McPhillamys Gold Project (SSD-9505): Submissions Report

I refer to the email dated 8 September 2020 inviting the Resources Regulator to provide advice regarding the McPhillamys Gold Project (SSD-9505) Submissions Report.

The current request for advice relates to the McPhillamys Gold Project Submissions Report dated September 2020, which provides information in response to submissions received, including that of the Resources Regulator noted above.

McPhillamys Gold Project  
Amendment report – rehabilitation and  
landscape management strategy addendum  
Figure 3.1

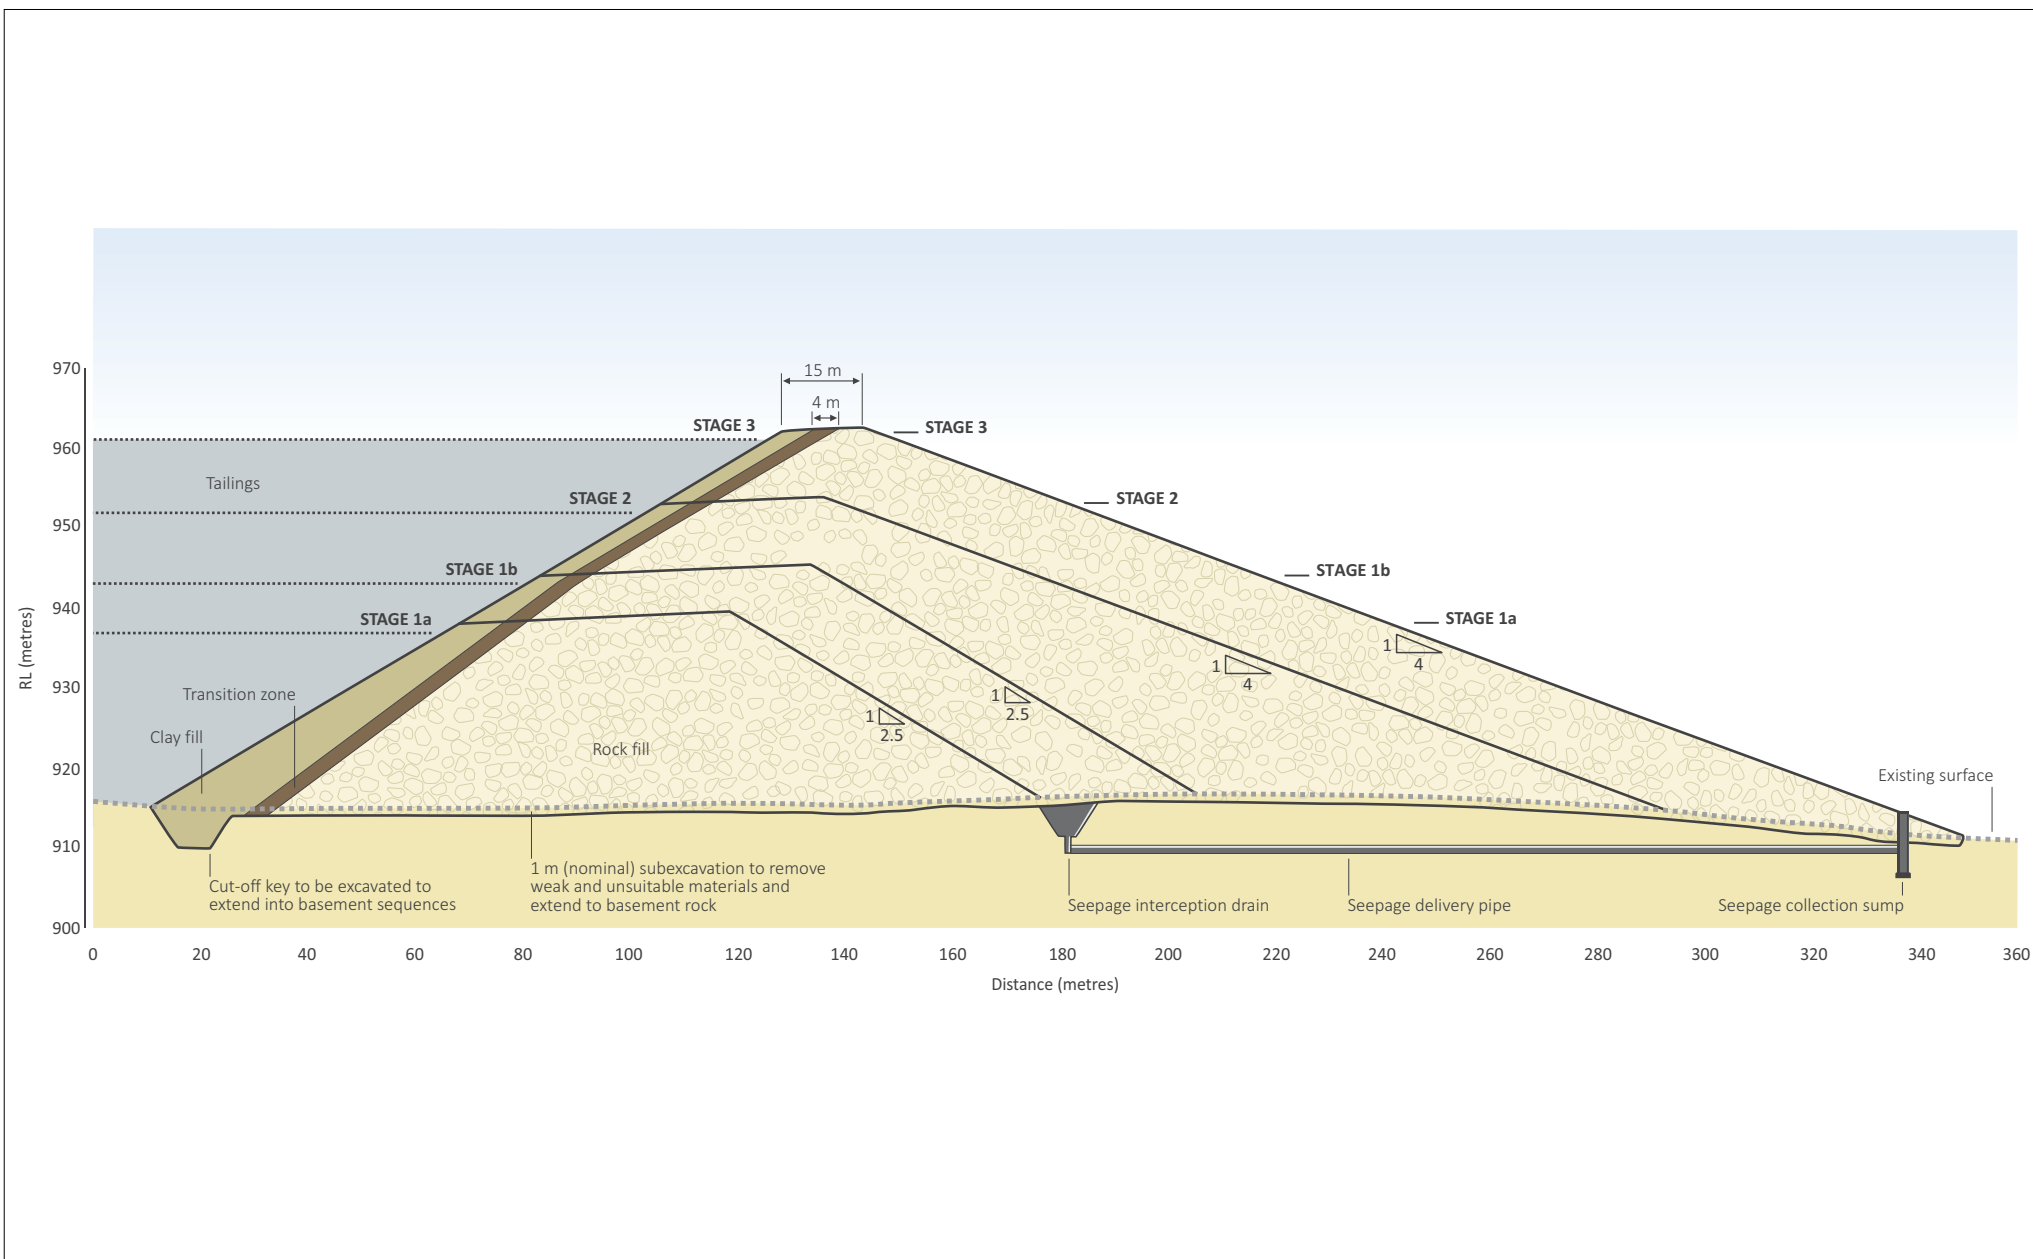
The Resources Regulator notes the information provided on the capping design for both the TSF and WRE to accommodate tree growth. Information provided that proposed capillary break on the TSF will be 'self healing' does not address the our concern regarding trees naturally establishing on the TSF and the capping being able to sustain this.

In order to validate the capping design to accommodate trees, we will require trials and research to assess the design as part of a Rehabilitation Management Plan (currently covered by the Mining Operations Plan requirement under the Mining Act 1992).

As part of the development of the Rehabilitation Management Plan/Mining Operation Plan, the Resources Regulator will seek clarification rehabilitation risks, identification of risk treatment controls, their implementation and monitoring of effectiveness specific to the capping design for the tailings Storage Facility and Waste Rock Emplacement.

McPhillamys Gold Project  
Amendment report – rehabilitation and  
landscape management strategy addendum  
Figure 4.7

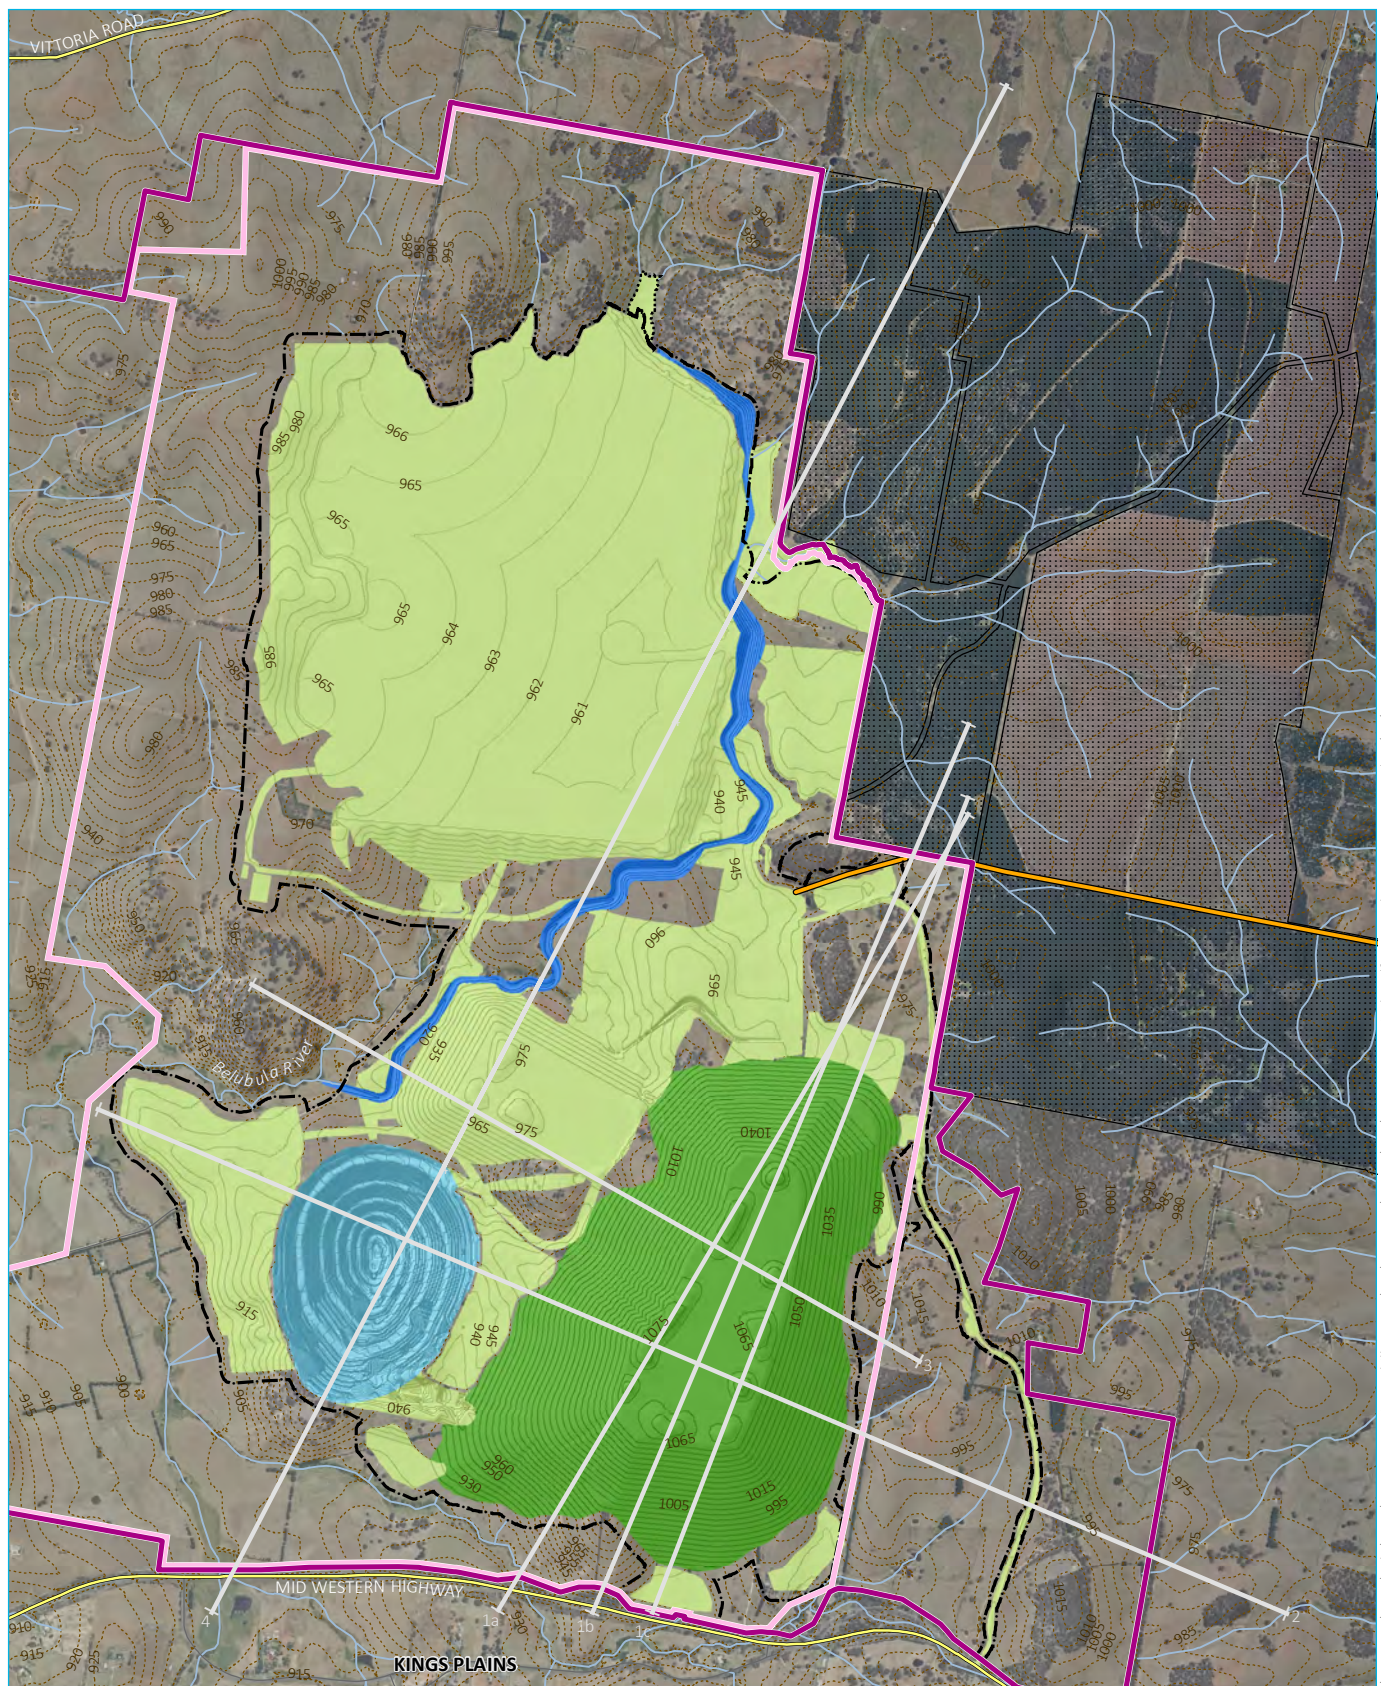
The Submission Report shows a reconfiguration in the final landform and surface water management for the TSF. The final landform now directs surface water east, rather the west. Although the conceptual final landform diagram (Figure 4.19) does not indicate any surface water management structures to allow surface water collected on the TSF to be discharged, information in the *Appendix D Tailings Storage Facility- design review and response to submissions* indicates that a "TSF beach drain" as well as an emergency spillway are to be incorporated into the final landform (refer to drawing 1000-301 Post Closure Layout Plan). Based on the revised information provided, the Resources Regulator requires the following to be addressed:

- Clarification that the the final landform will incorporate both a TSF beach drain and an emergency spillway i.e. update to the conceptual final landform diagram (Figure 4.19).
- Confirmation of the performance of these structures to withstand significant rainfall events, noting that both ANCOLD and the recent ICMM Global Tailings Review specify design criteria of 1:10,000 AEP for tailings facilities post closure.
